From: Sarah Burrow [REDACTED]
Sent: 29 January 2020 17:42
To: Planning.Responses [REDACTED]
Cc: Paul Cann [REDACTED] David Spring [REDACTED]
Subject: RE: Planning Consultation on: BE/126/19/PL

Engineers Comments Regarding Surface Water Drainage

Site Address: Land at Phase 1A Oldlands Farm Shripney Road Bognor Regis
PO22 9NN

Description of Works: Erection of a discount convenience retail food store (Use Class A1)
& parking, landscaping & other associated works

PROPOSED SITE PLAN

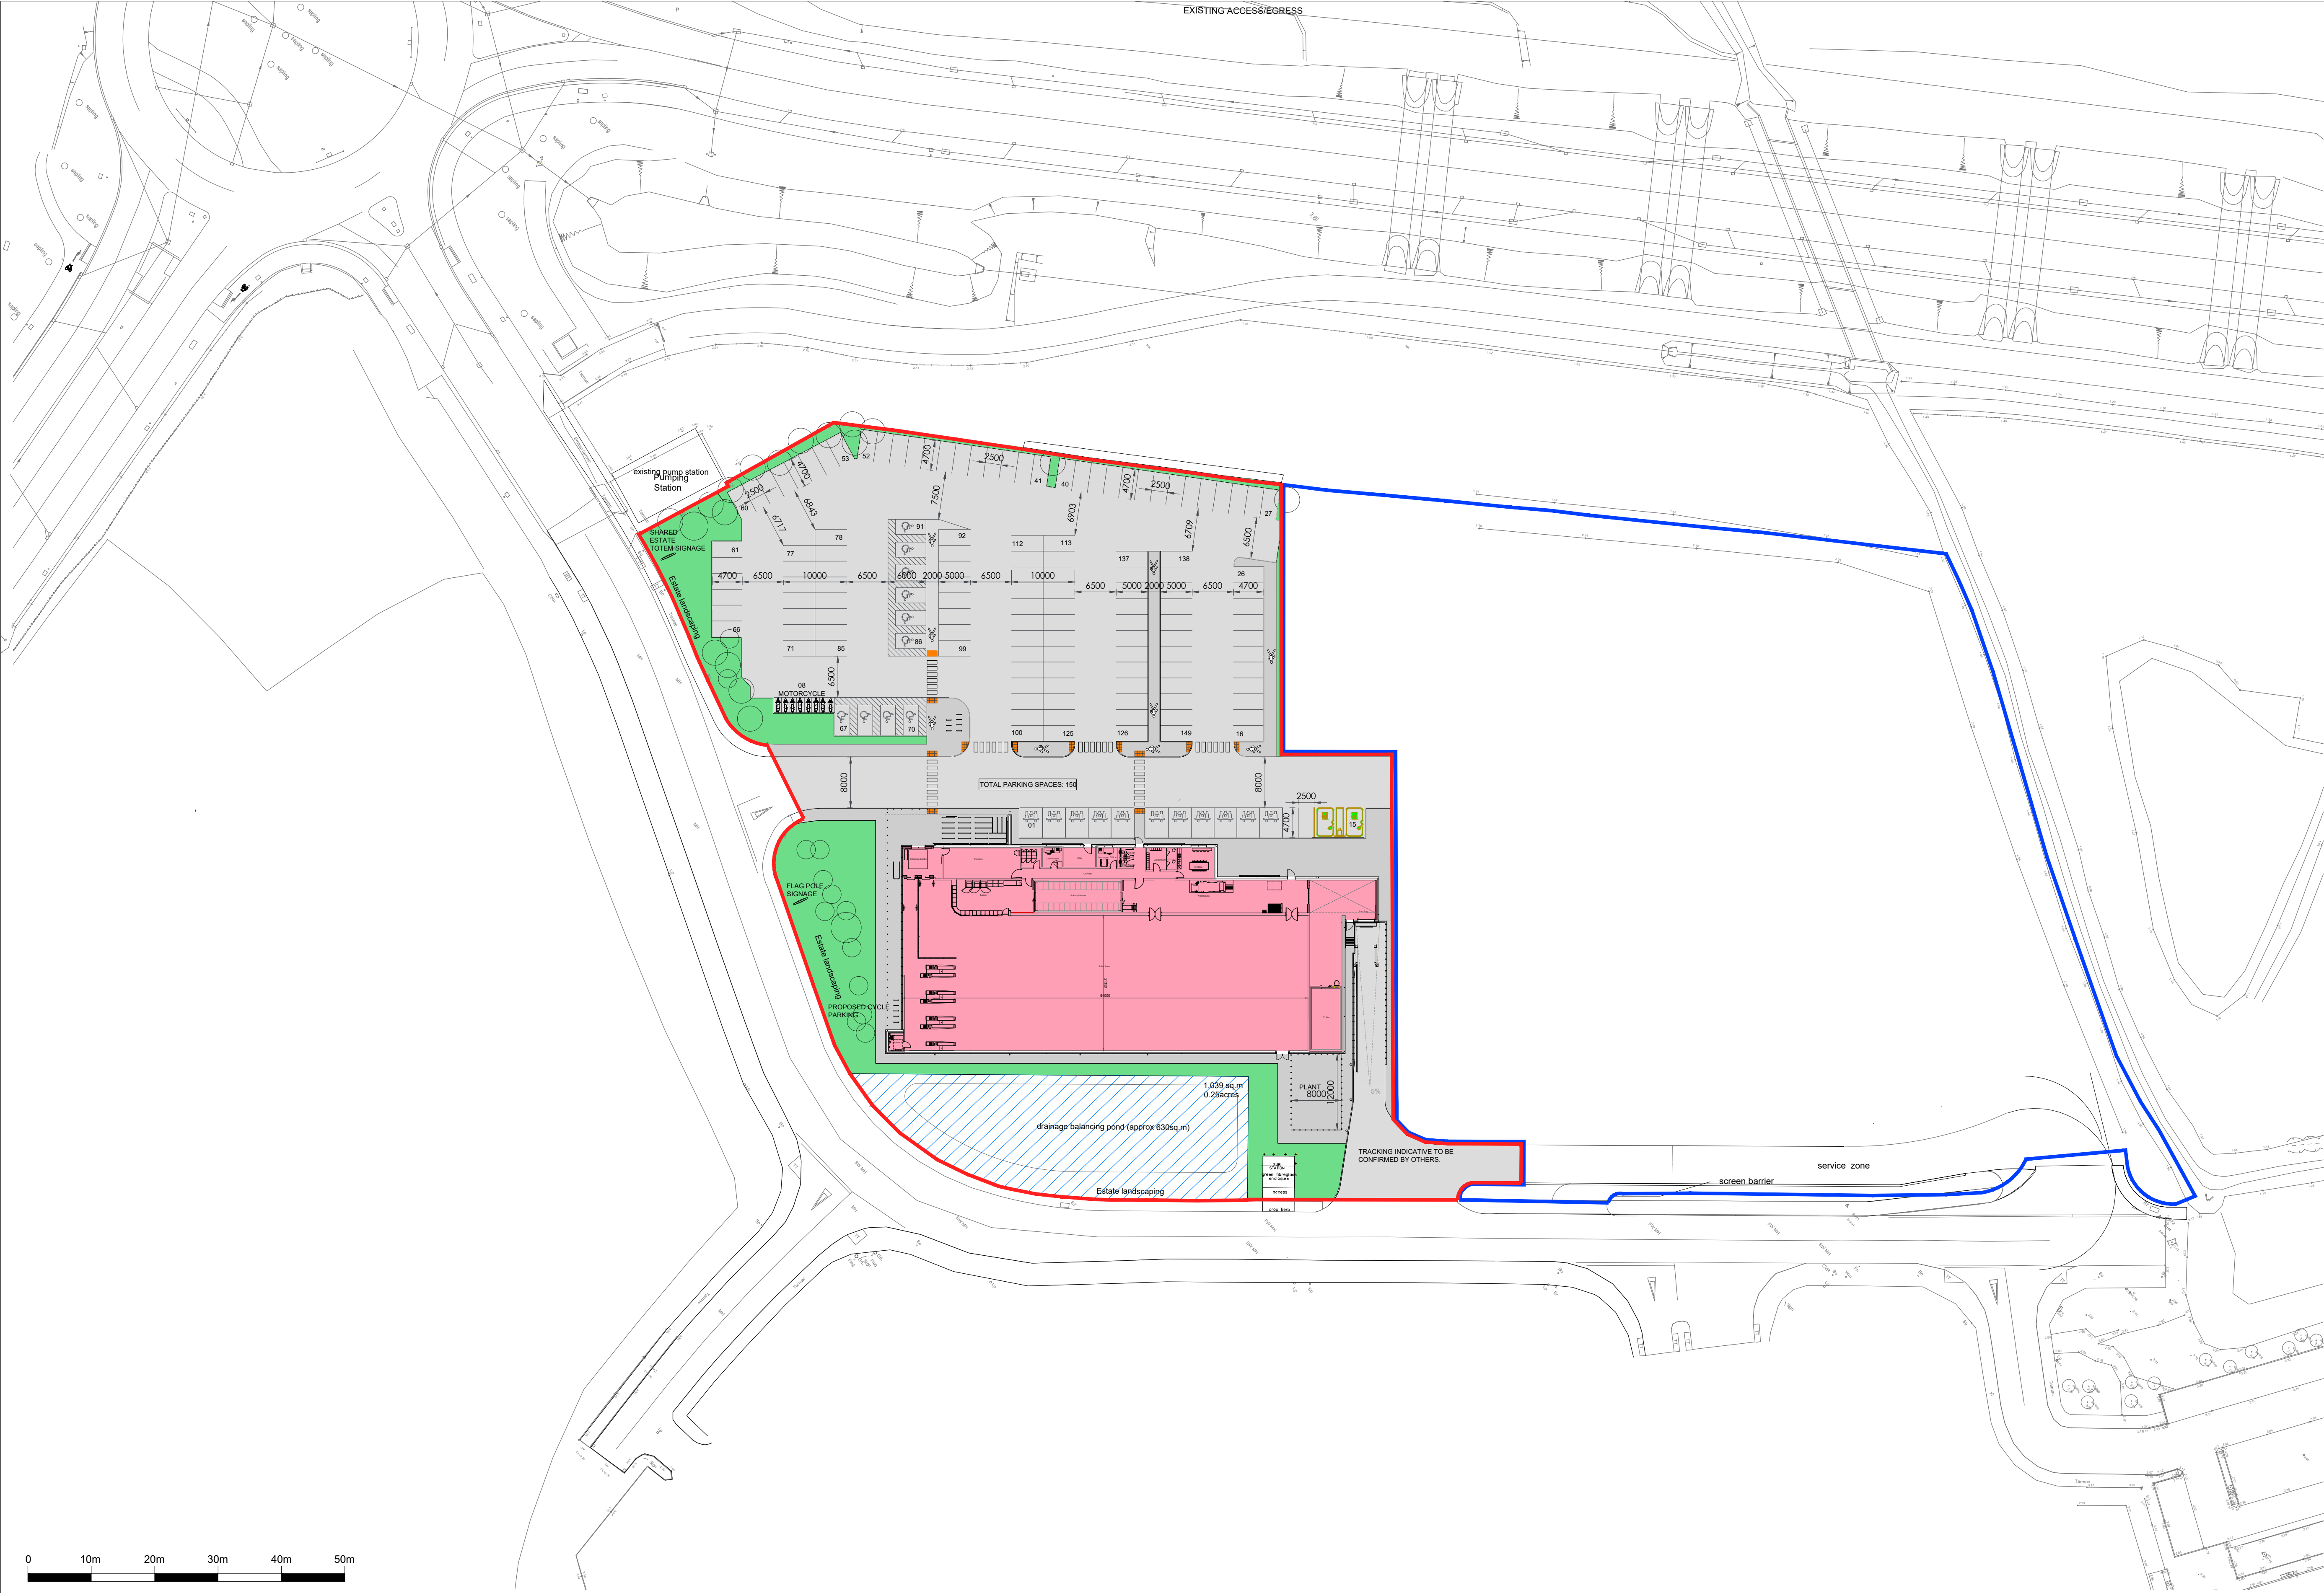
3. The Flood Risk Assessment (but not the Drainage Strategy) proposes permeable paving of the parking areas which we would be keen to keep to add additional storage and further improve water quality.

4. We require a 3m easement from the top of the bank of the attenuation basin (on all sides).
